Application number: 2023/91280	
What is the application for?:	Quarrying operations for the extraction of clay, shale and incidental coal and s
Address of the site or building:	Bromley Farm Quarry, Barnsley Road, Upper Cumberworth, Huddersfield, HD8 8PD
Postcode:	S36 4HG

Type of comment: An objection	
Do you wish your comments to be published on the website anonymously?	No

Plan Title: SITE ACCESS SECTIONS

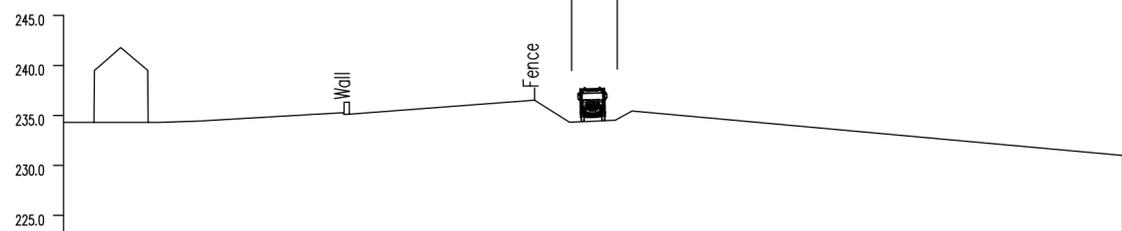
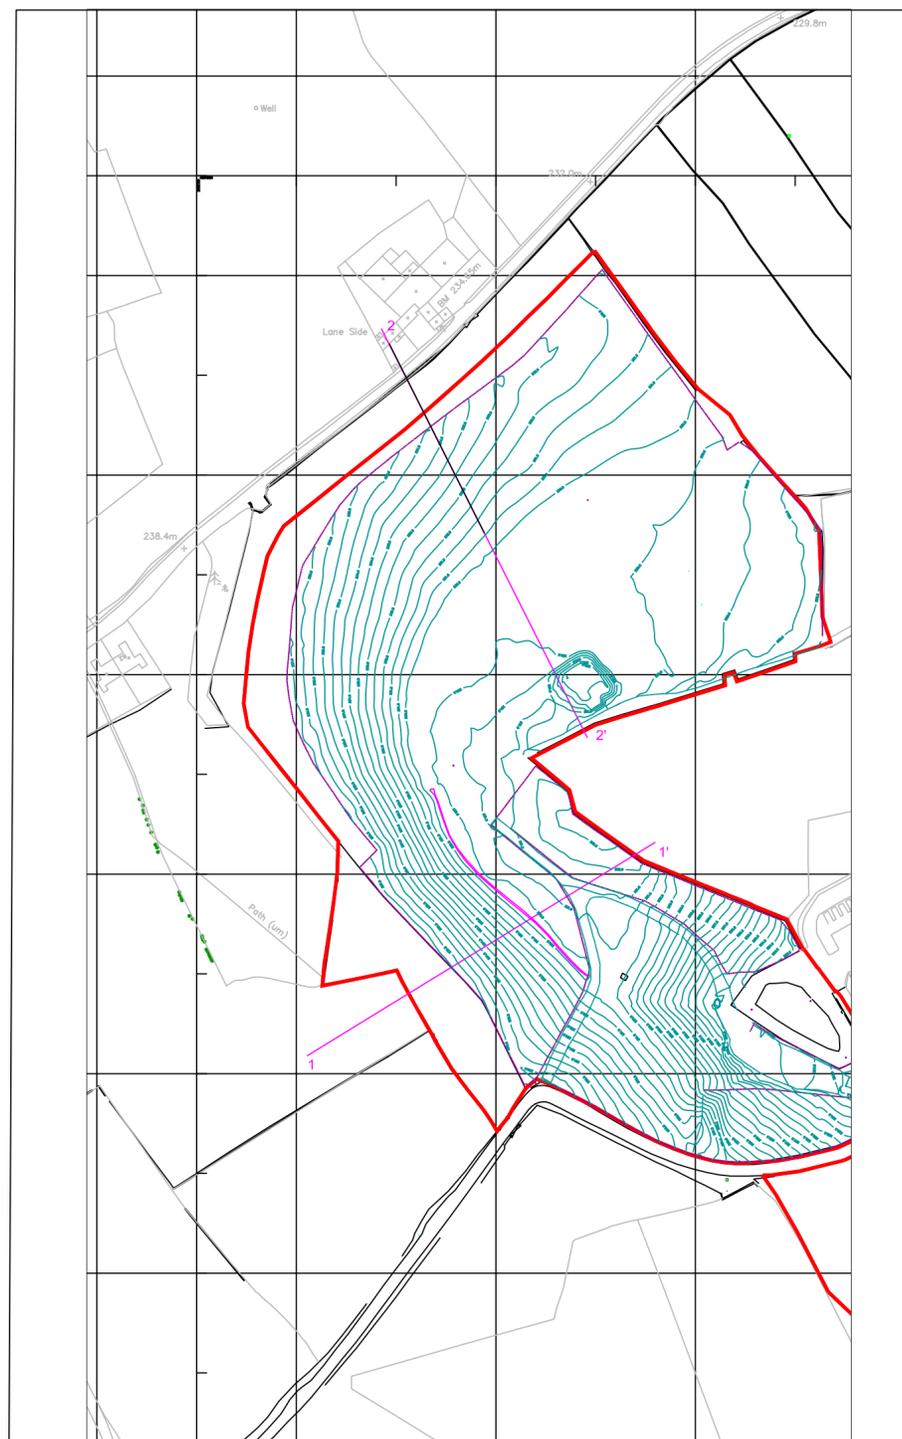
4 As I stated in my original objection the access road to the quarry is not wide enough. This issue has not been addressed see the reference in the aforementioned Transport Report submitted as part of the Anti Quarry Groups recent submission. The type of vehicle used to transport the clay has changed which only exacerbates the problem.

HGV ROUTING PLAN

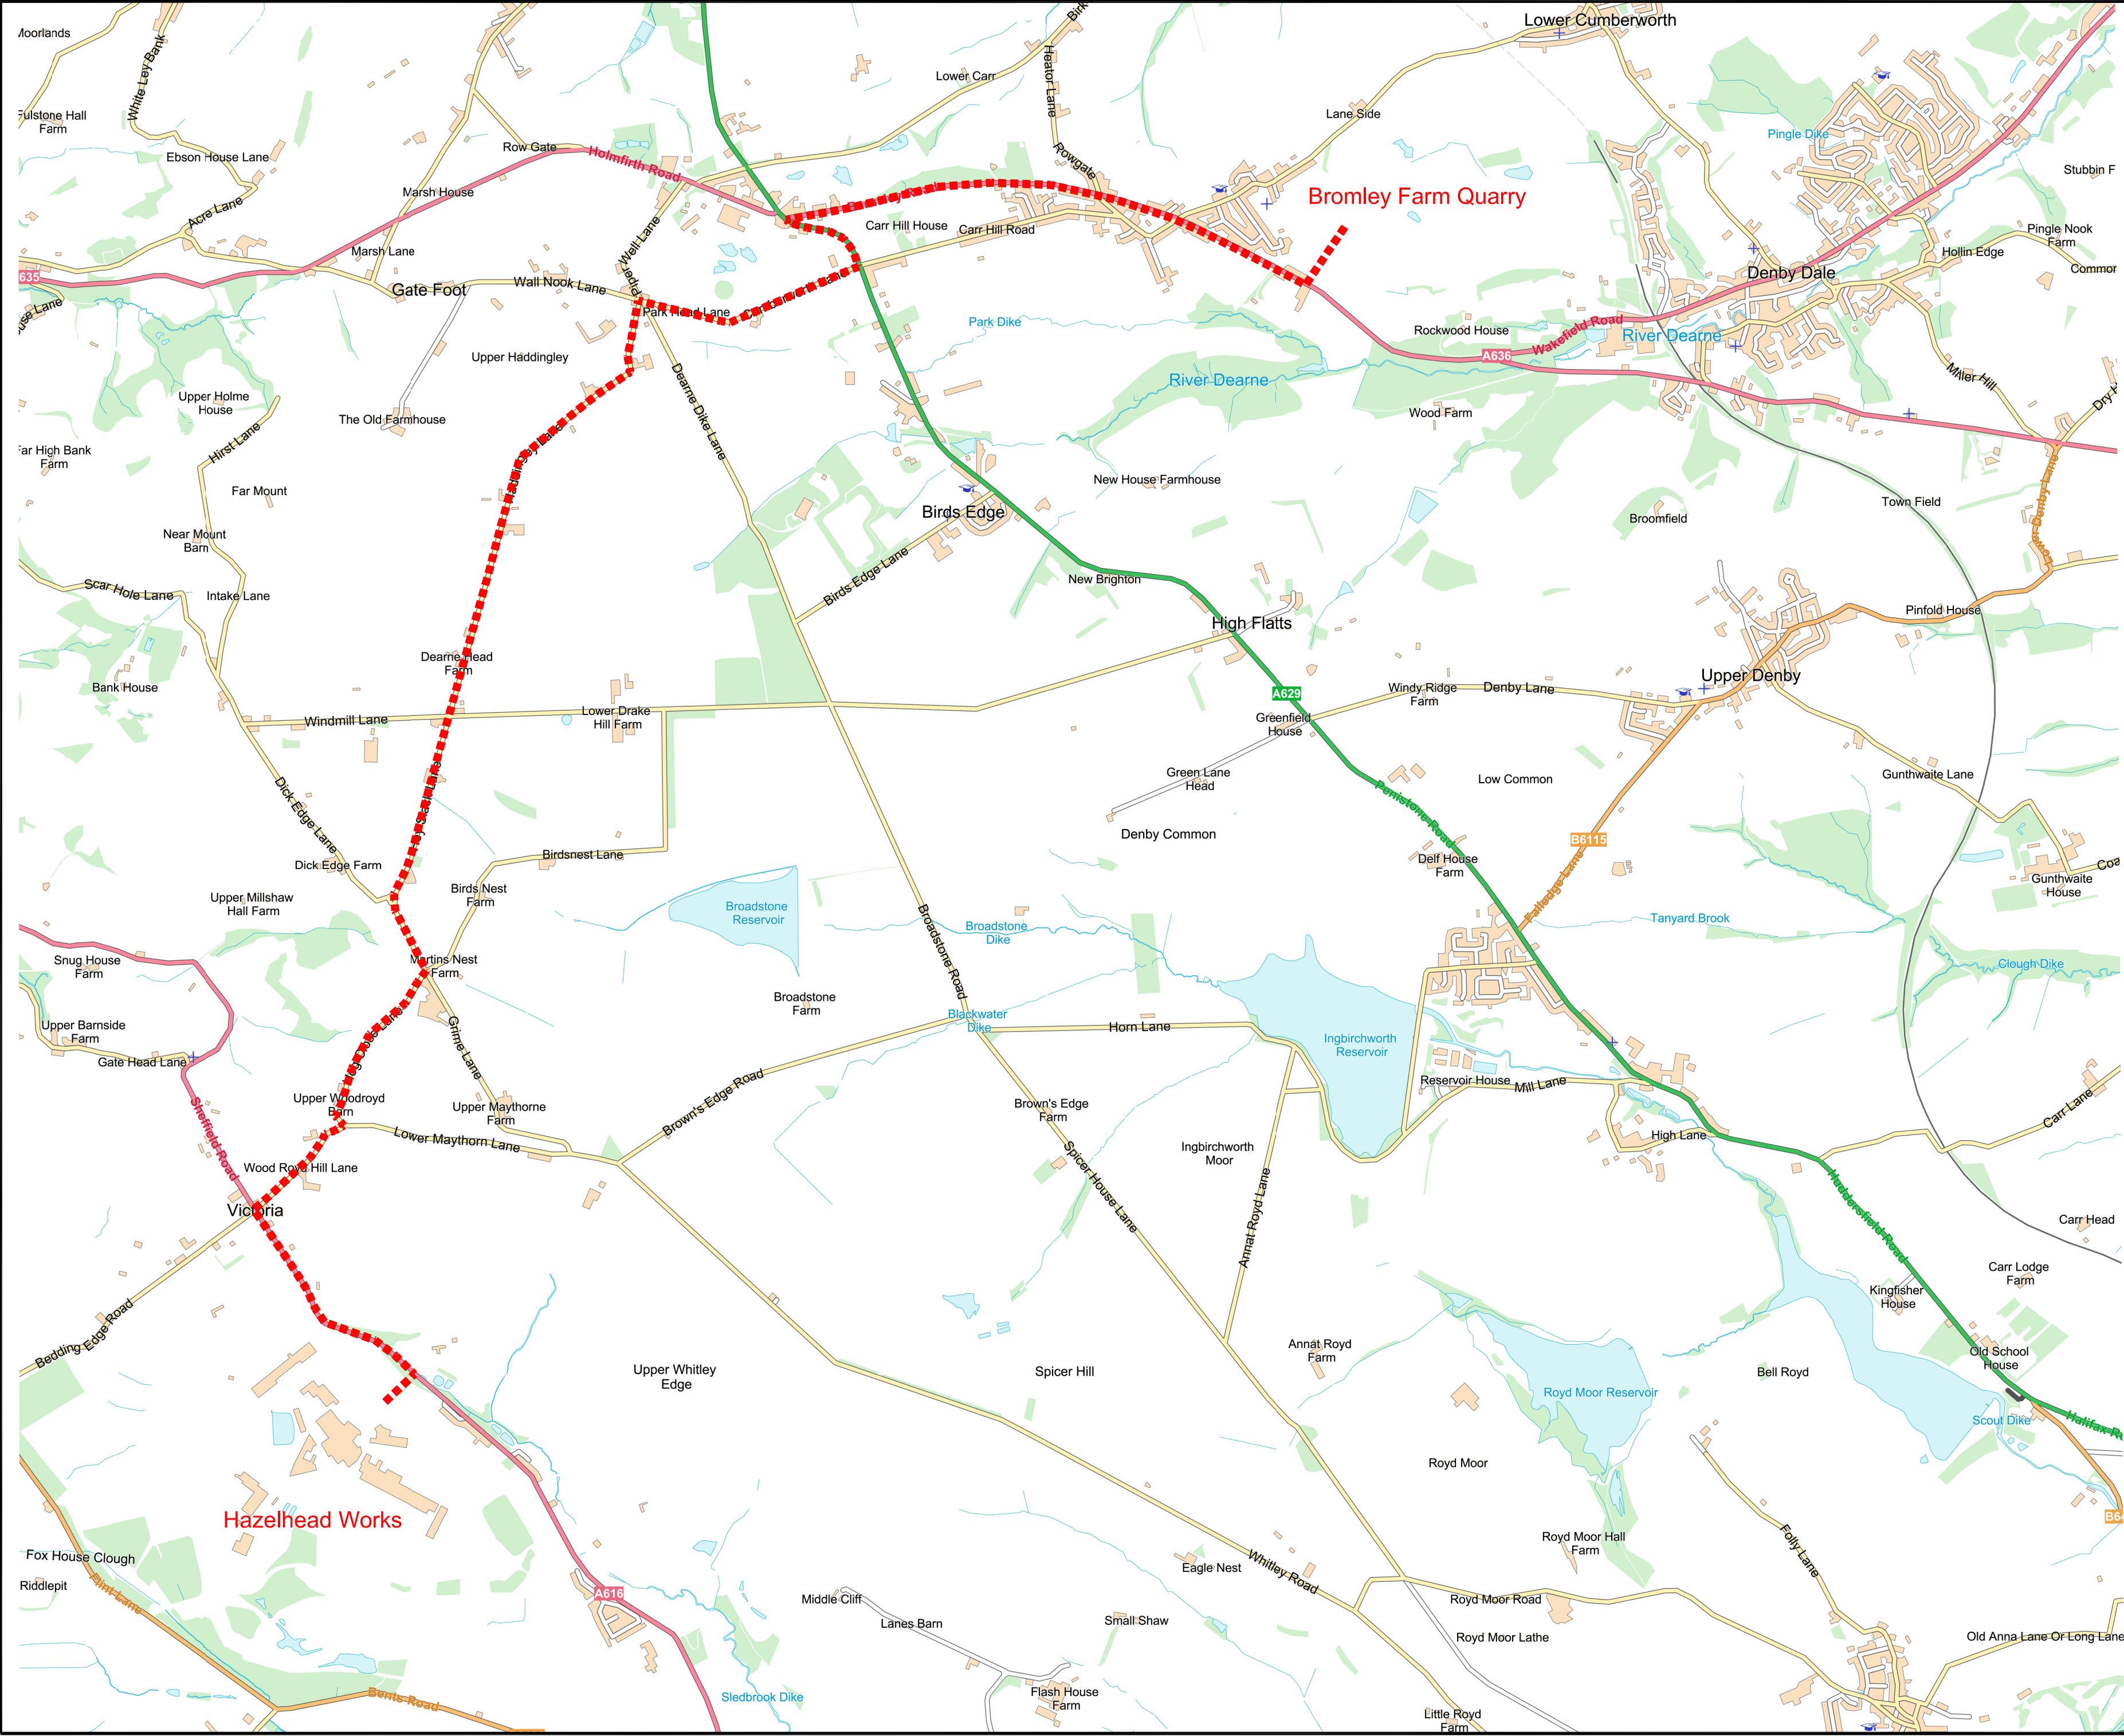
1. The traffic assessment includes no account of the existing use of HGV lorries at the other local Quarries. It is the cumulative affect of these together with the new proposal which need to be considered.

2 The traffic route involves a very hazardous turn at the notorious Sovereign crossroads. Many accidents have been reported here and in my expeience Carr Hill Road will still be used as quarry vehicles currently use this route.
